**From:** [PMO](#)  
**To:** [Wylfa Newydd](#)  
**Subject:** RE: IACC Deadline 2 Submission : Local Impact Report - Introduction (email 3)  
**Date:** 04 December 2018 20:37:35  
**Attachments:** [image001.png](#)  
[image002.png](#)  
[image003.png](#)  
[Annex 1D-1O \(Batch 2 of 2\).zip](#)

**Review of Horizon's DCO Submission (Logistics)**

Figure 1-1 Logistics Centre Order Limits

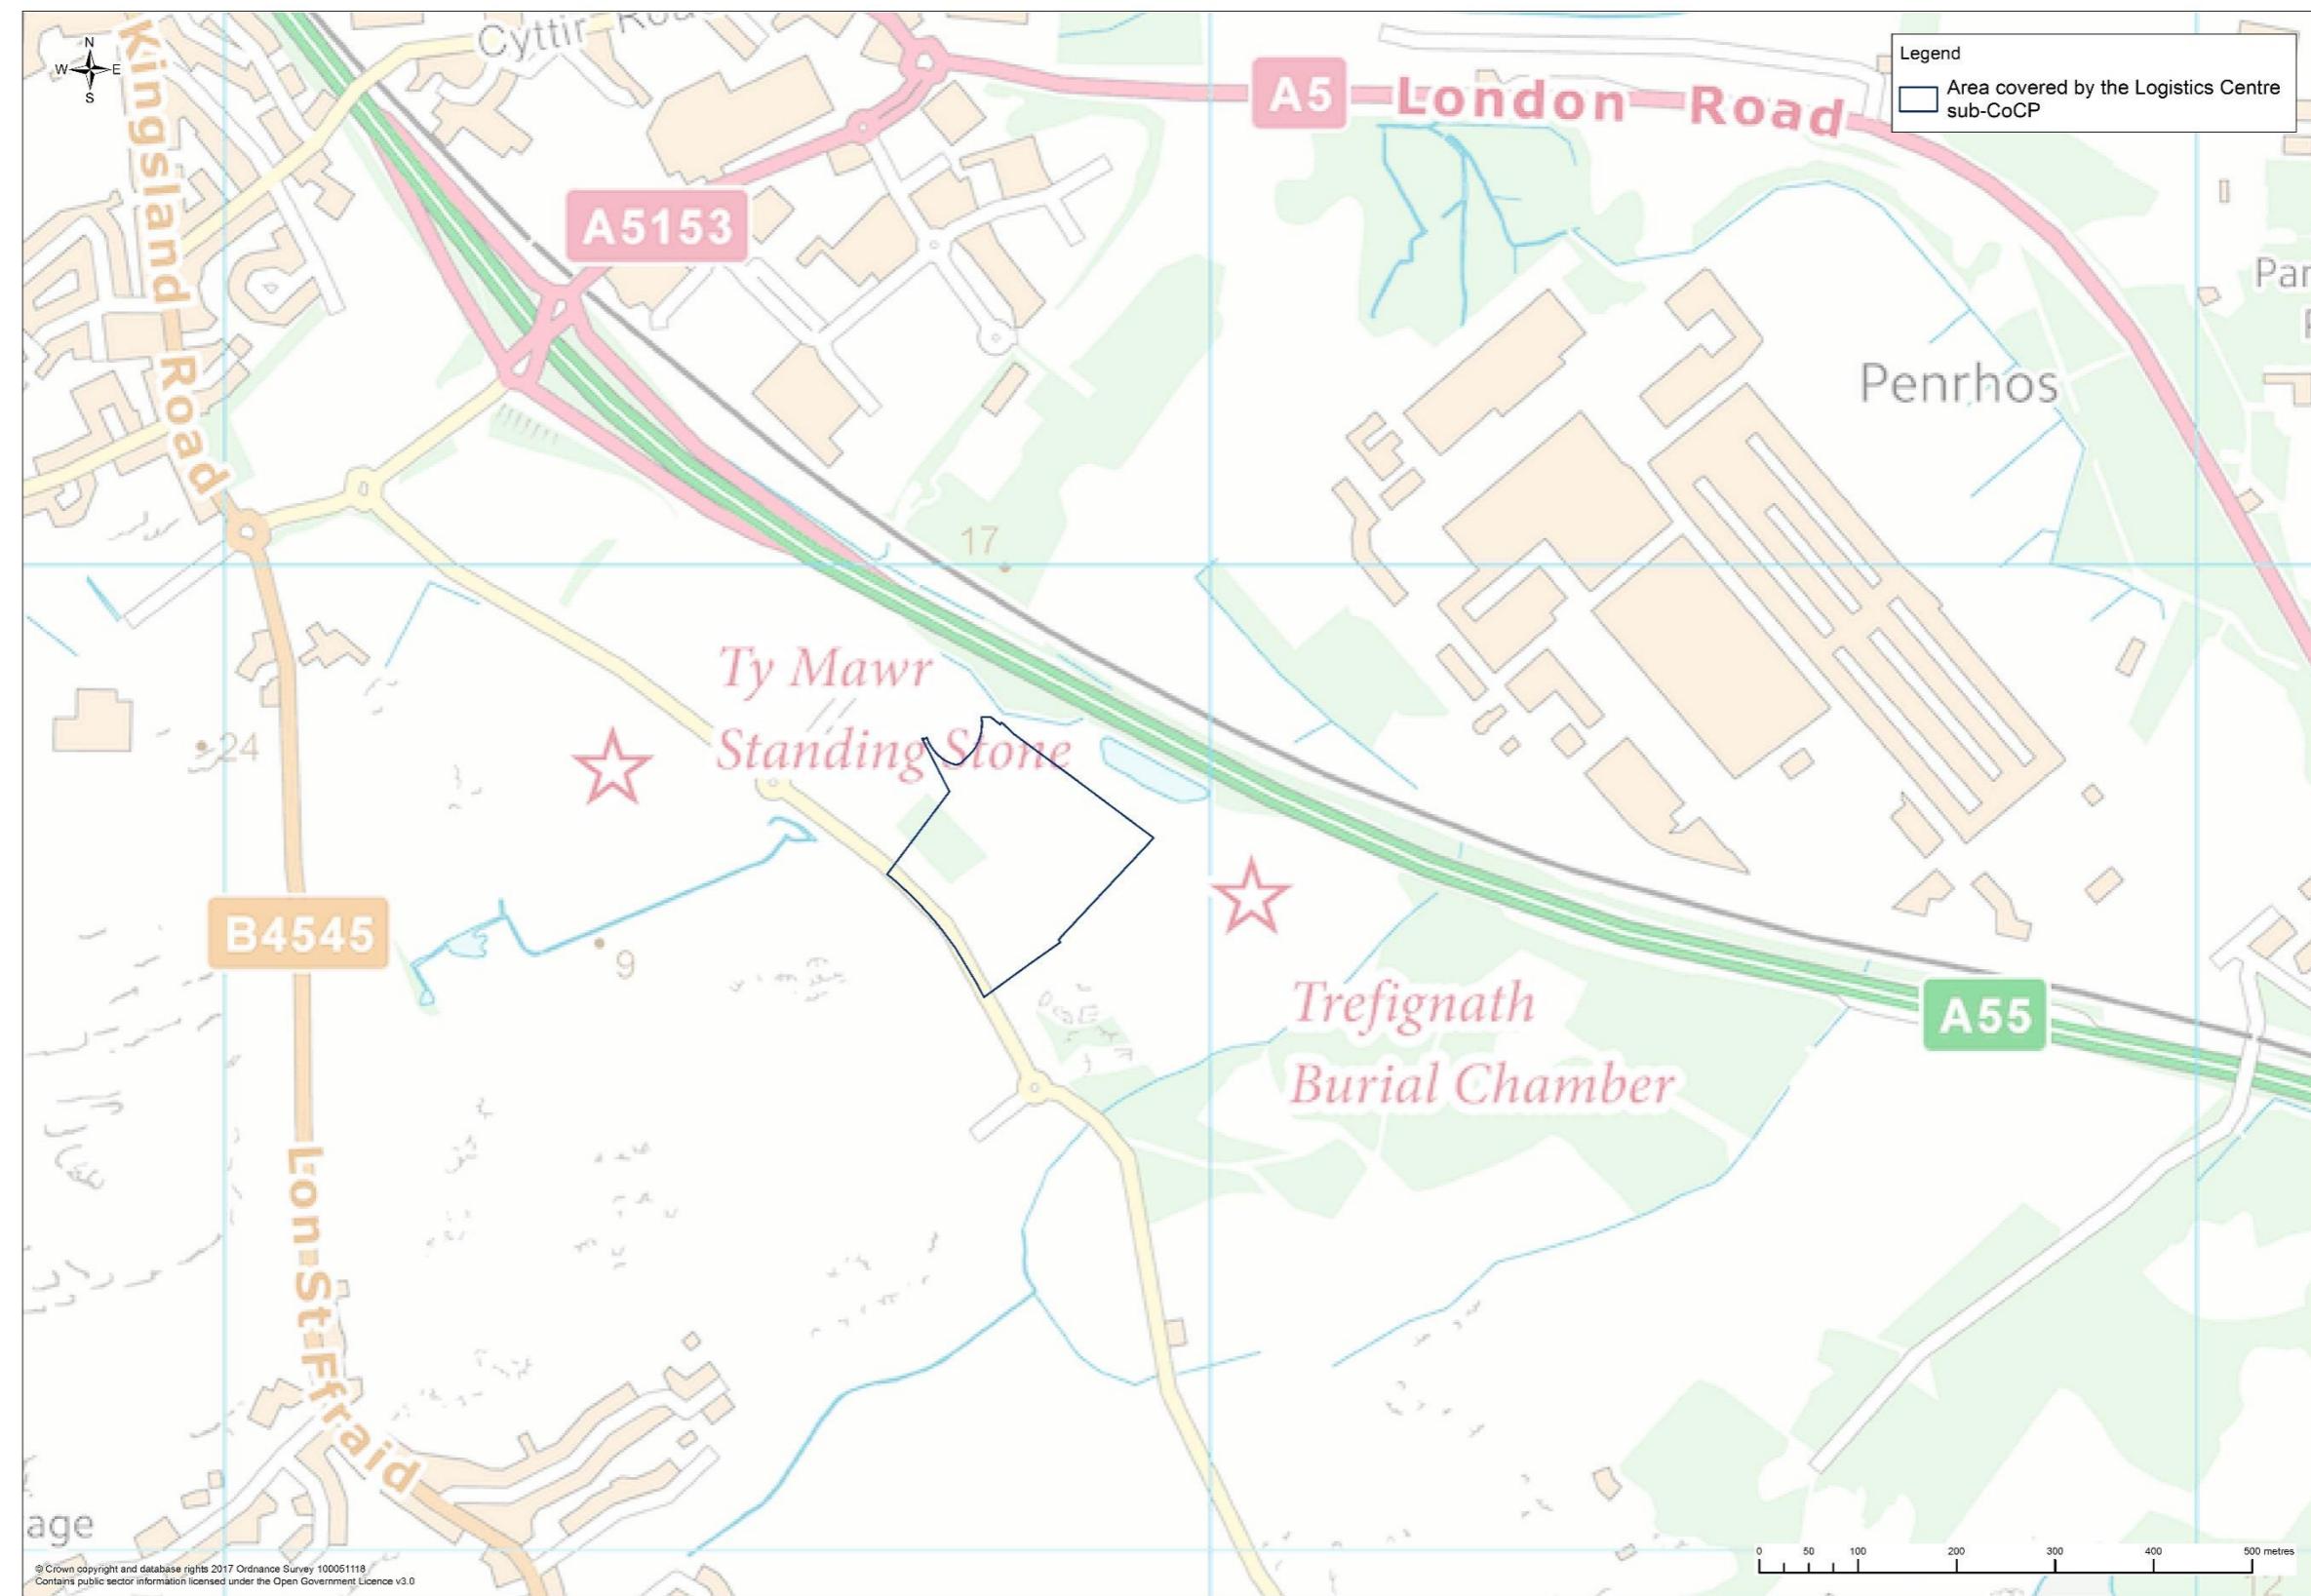
- ii. Modification to the design in order to retain or as much as possible of the existing small woodland copse in the western corner of the site (see also Visual comments below).

- vi. Environmental Lighting Impact Assessment – The submitted drawings provide information on the location and height of columns and information is also provided within regard to the proposed light levels. The Council would wish to receive confirmation via an impact assessment that the levels of light will be limited on nearby waterbodies, watercourses, retained hedgerow and boundary habitats (which are also landscape elements) and on nearby sensitive visual receptors (see also comments under Ecology).
- vii. Assessment of effects on landscape fabric - an assessment of the likely direct effects (adverse and beneficial) of the construction, operational and decommissioning phases of the proposed Parc Cybi Logistics Centre on the existing landscape fabric (elements) of the site should be provided.

4.5.4 IACC is of the view that the potential for further on-site mitigation is limited. Clarification is however sought firstly that the 2.4m high paladin fencing has a neutral colour finish to minimise any potential visual contrast with the elements within and beyond the site against which it will be viewed; and verification that the lighting columns in the central part of the site need to be 12m high. Their height increases their visual prominence in views from the immediate surroundings of the site e.g. Viewpoint 1 at Trefignath Burial Chamber.
